Application number: 2019/91327	
What is the application for?:	Reserved matters application pursuant to outline permission 2017/90207 for erect
Address of the site or building:	Thongsbridge Mills, Miry Lane, Thongsbridge, Holmfirth, HD9 7RW
Postcode:	HD9 7RW

1_Huddersfield Road Elevation 1: 200

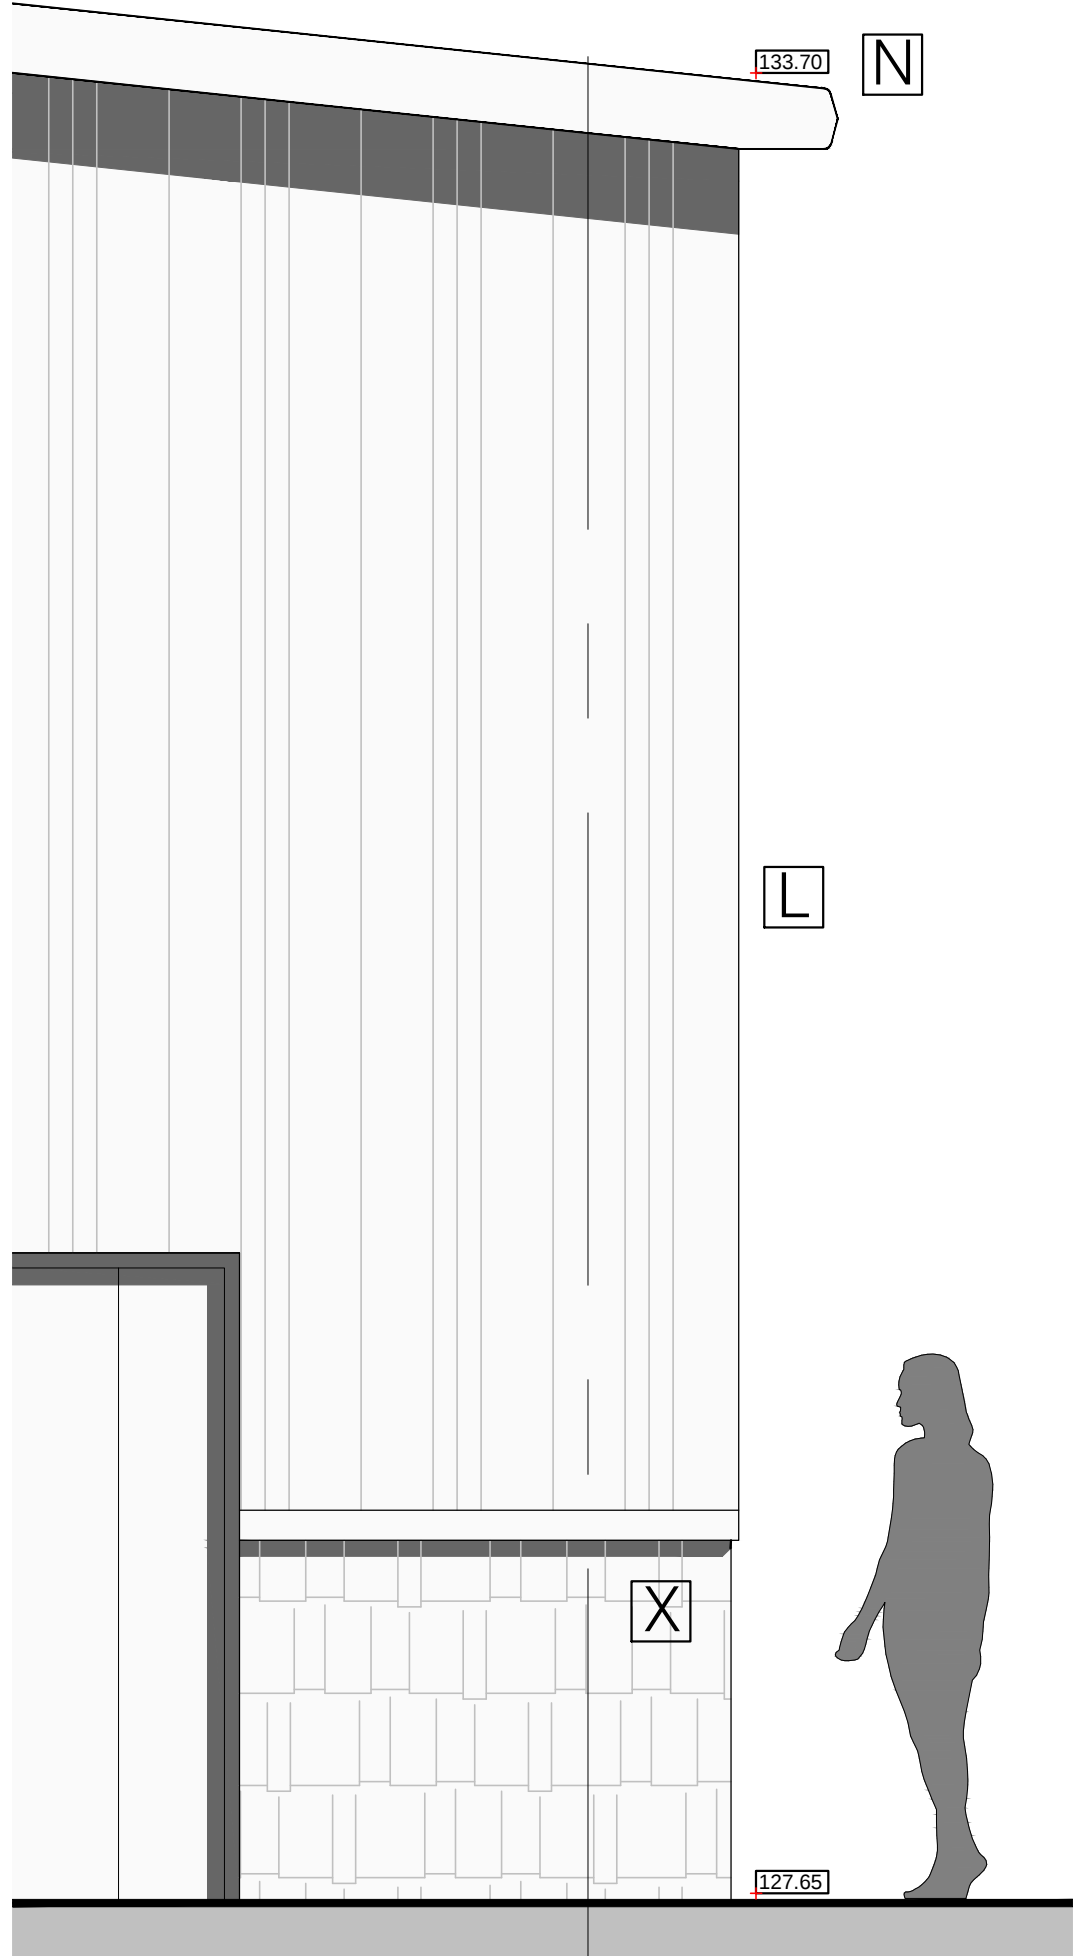
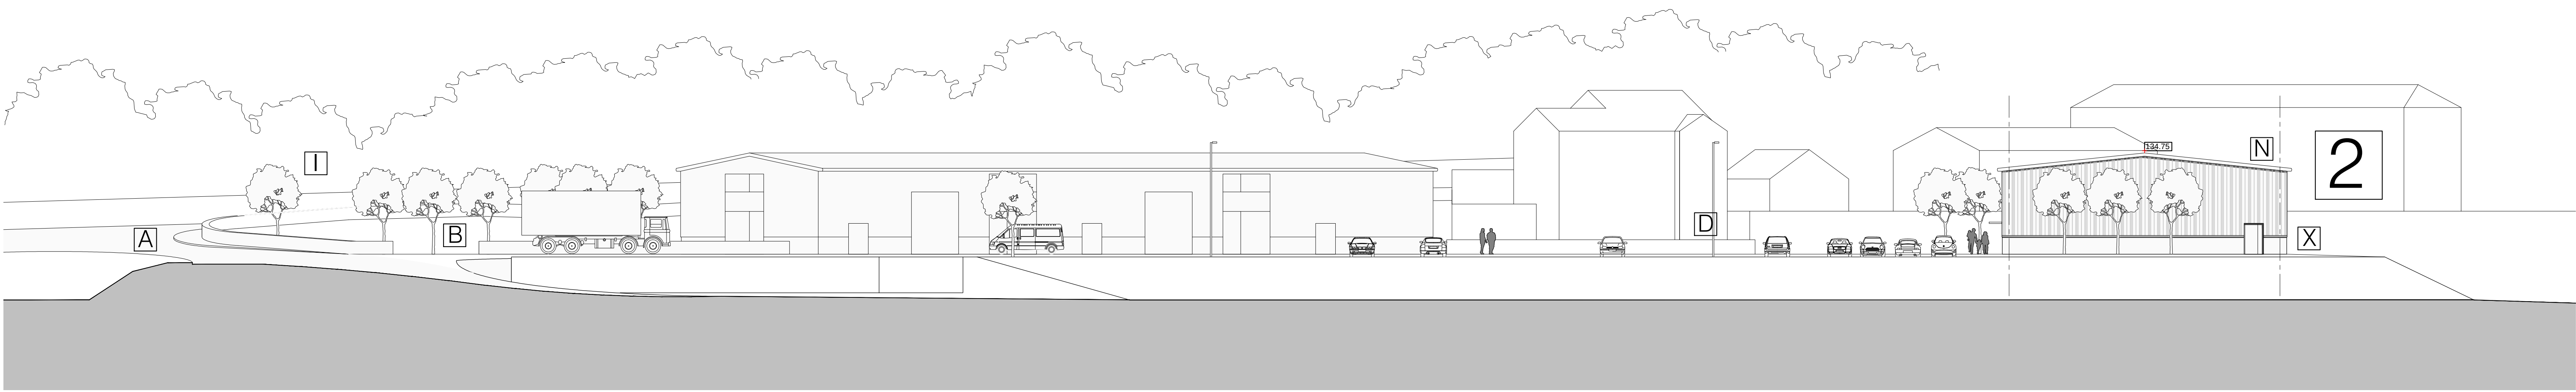
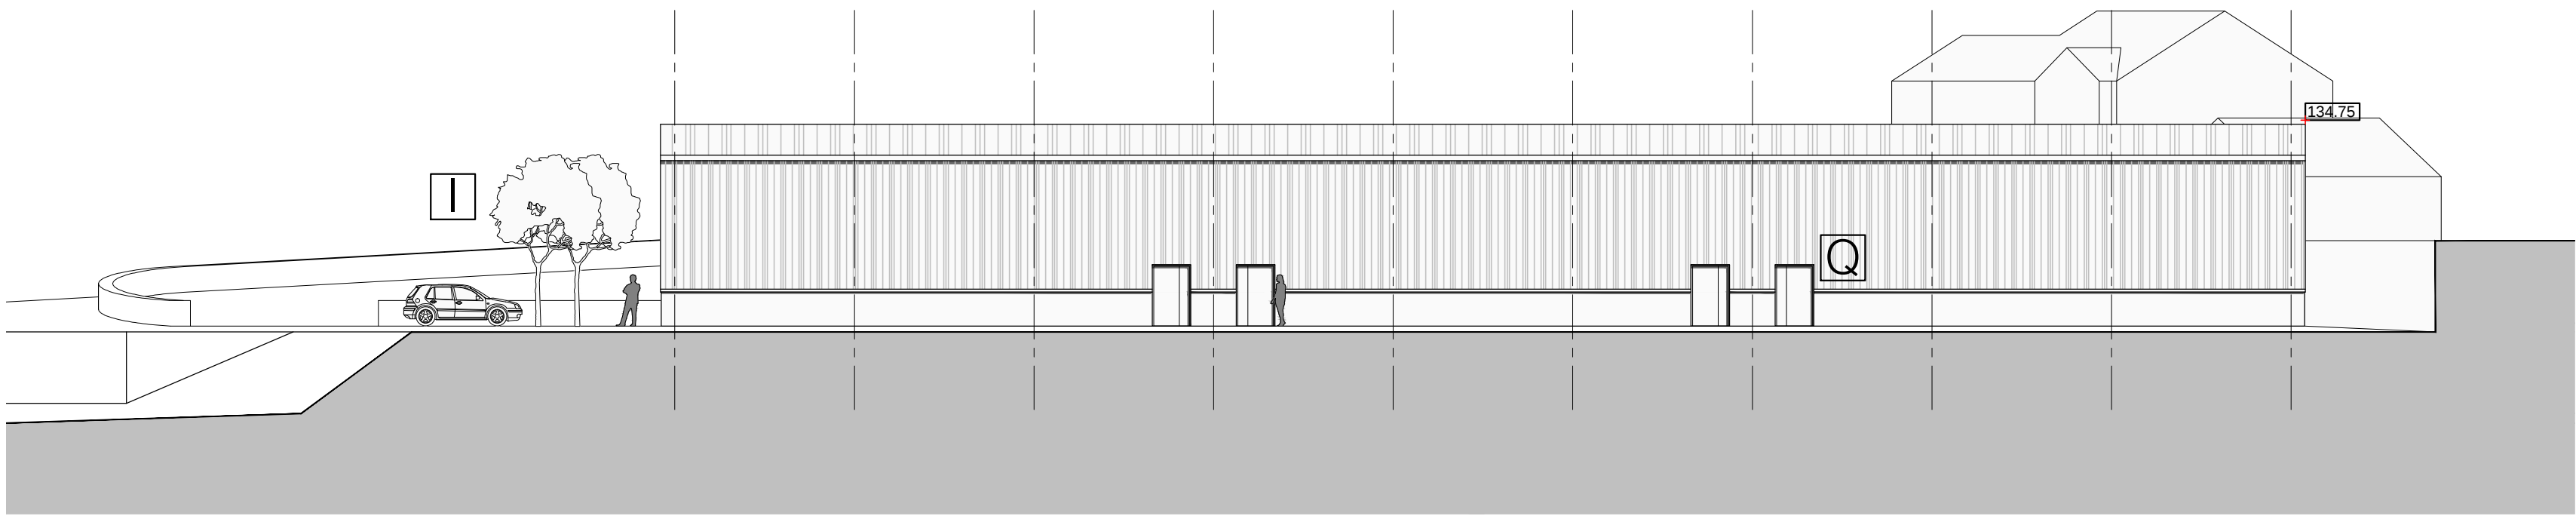
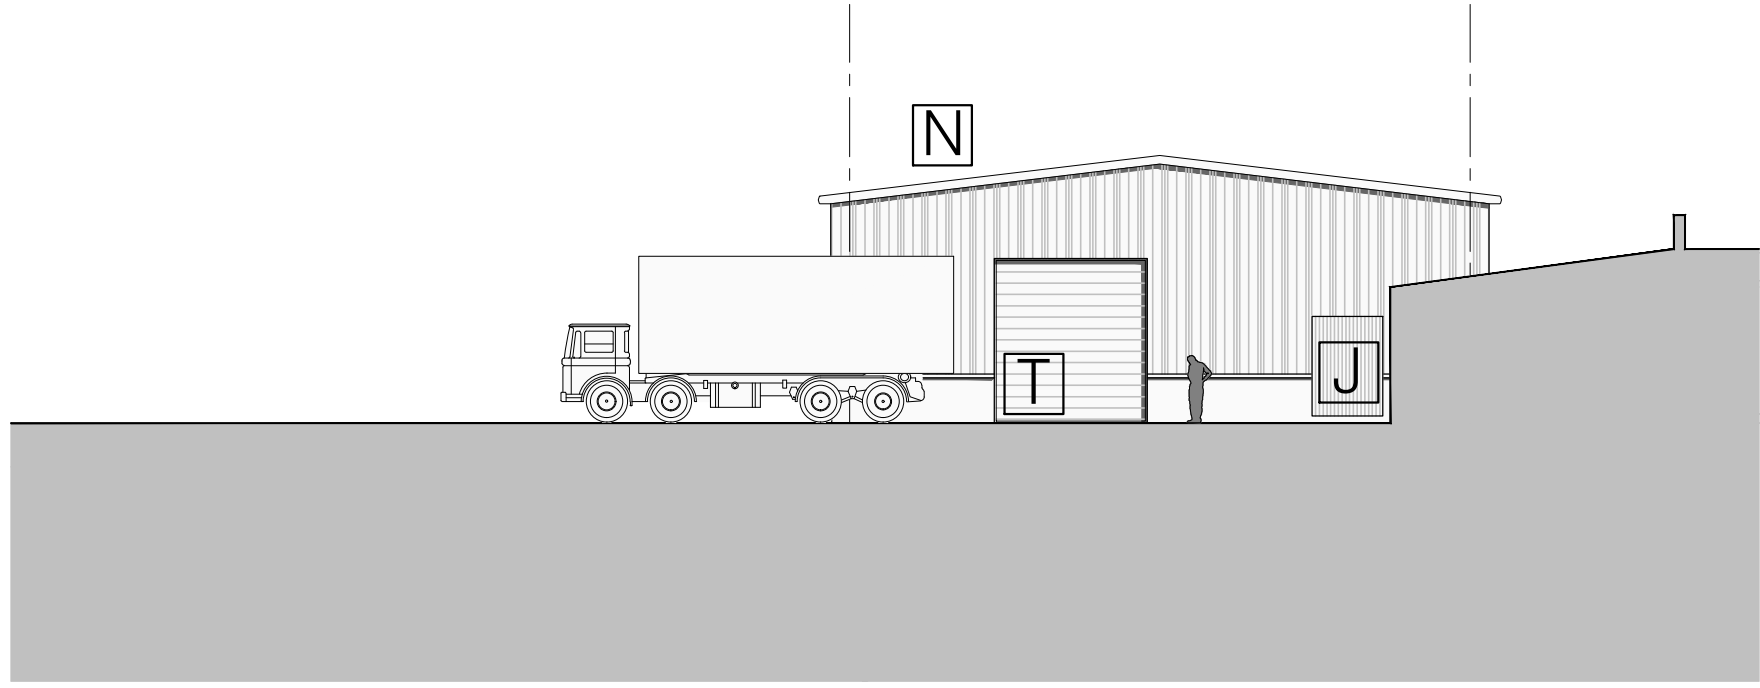
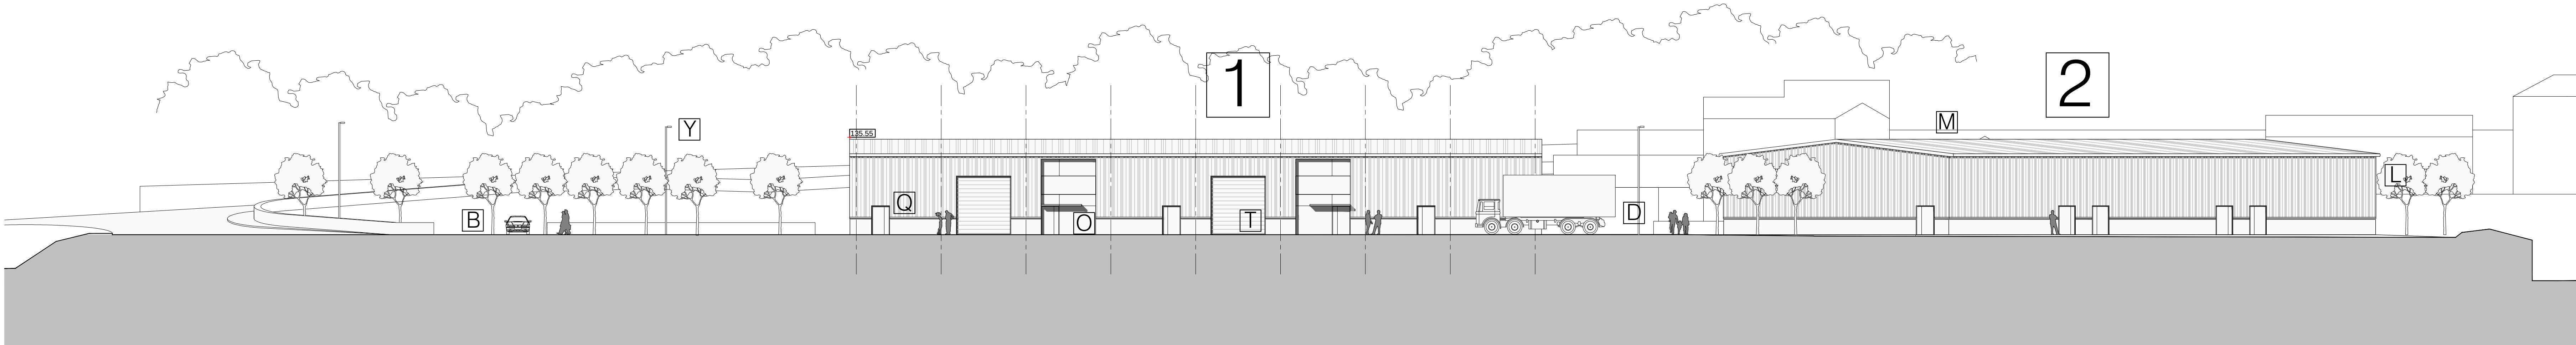
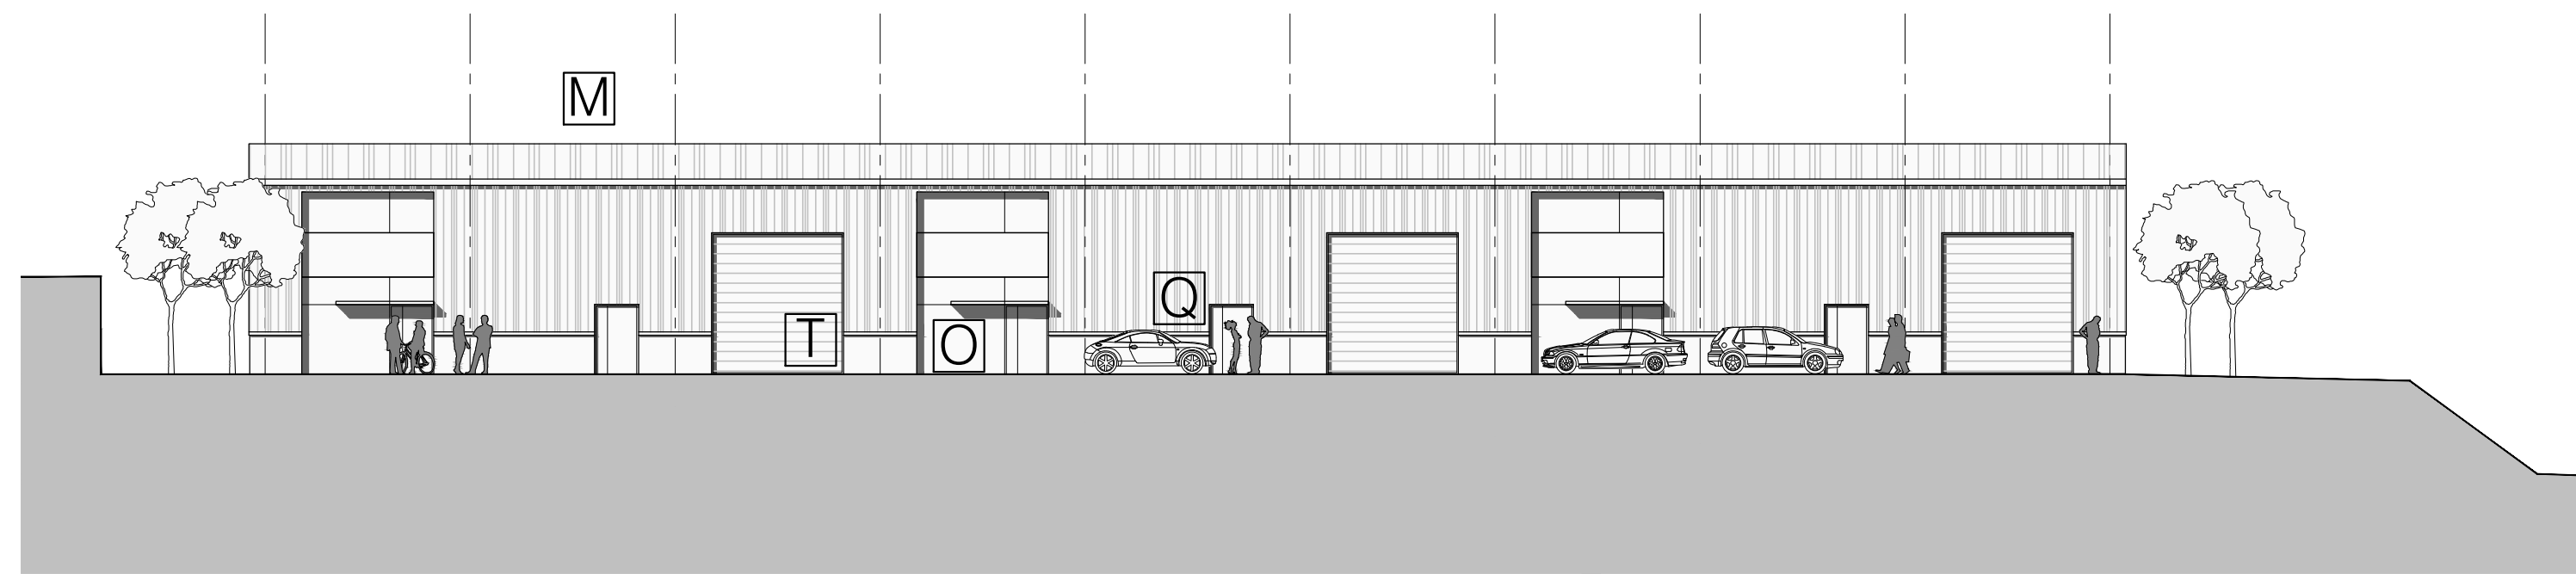
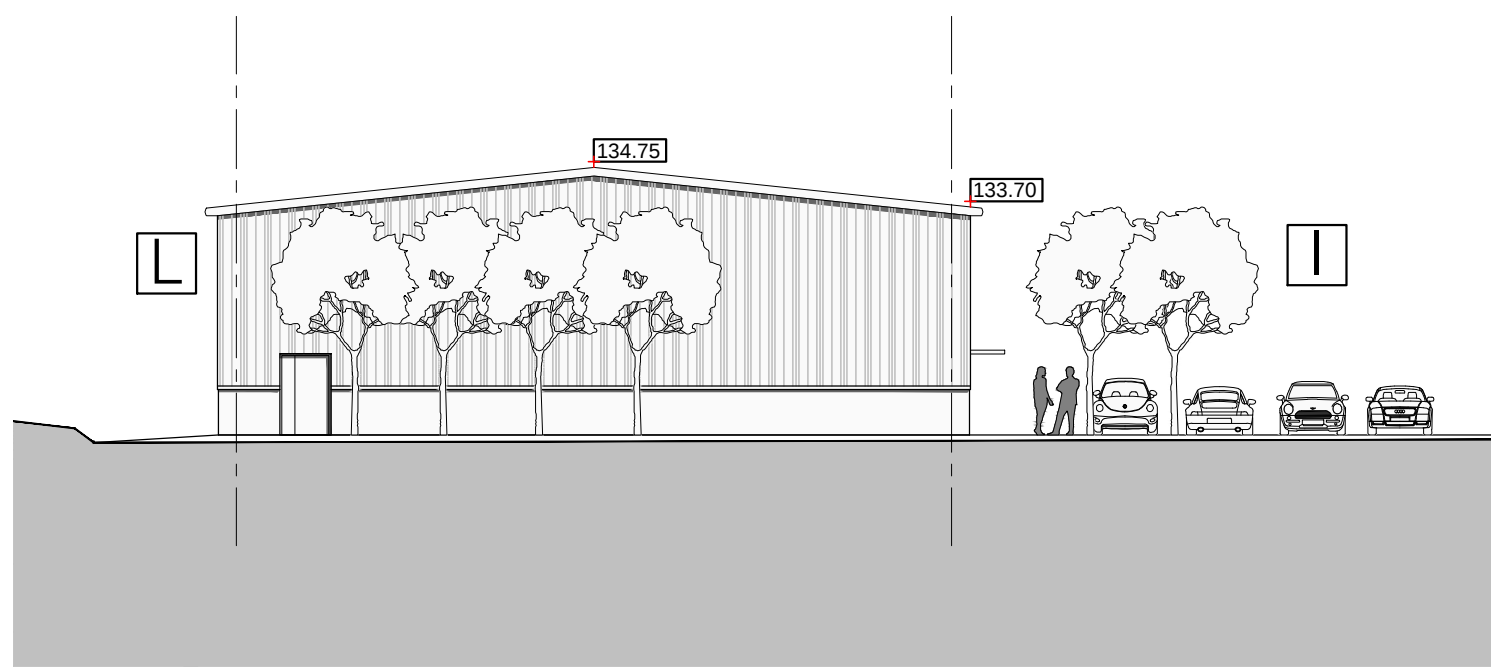
The proposed development in its current form will have a serious adverse impact on our residential amenity and will have an overbearing impact

and the scale and height of the proposed building.

The proposal will have an overshadowing impact on our living accommodation and from early morning to afternoon. Our natural light will therefore be seriously compromised for at least 6 months of the year.

To summarise, the proposal, will have a considerable overbearing negative impact This will seriously blight and have a huge negative impact on our day to day living and well-being.

We therefore respectfully request that Kirklees Planning give full consideration to our concerns regarding the current proposal. We would expect as a minimum that further thought is given to the layout and scale of the proposed development, so as to have considerably less impact on our lives.
